PROPOSED MORGAN OFFSHORE WINDFARM

PLANNING INSPECTORATE REFERENCE: EN010136

RE: NATURAL RESOURCES WALES' DEADLINE 6 SUBMISSIONS

Figure 1.1: Example change management procedure to update the Final UWSMS.

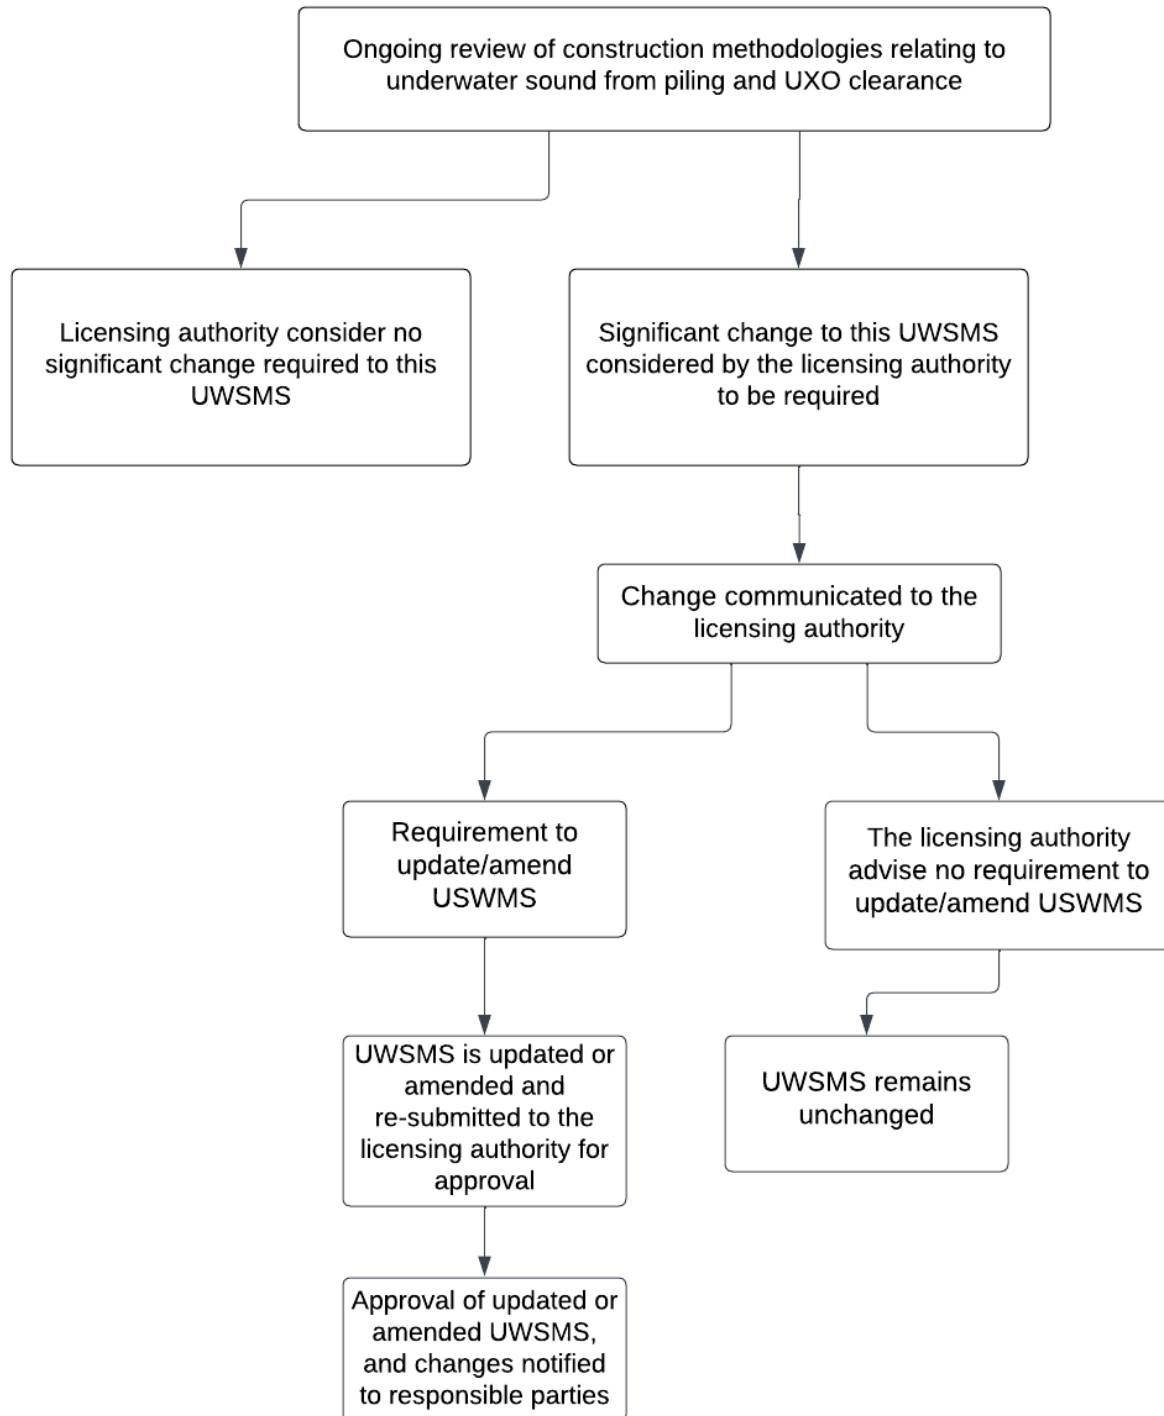
16. Section 1.1.2.2 states 'The UWSMS will be the mechanism for agreeing the final requirements of mitigation before the commencement of construction. The Final UWSMS will be agreed with the MMO in accordance with the DCO.' NRW recommend that the UWSMS, MMMP and general approach to mitigation be developed in consultation and agreement with all the SNCBs, and then agreed with the MMO as appropriate, and this statement be revised as such.
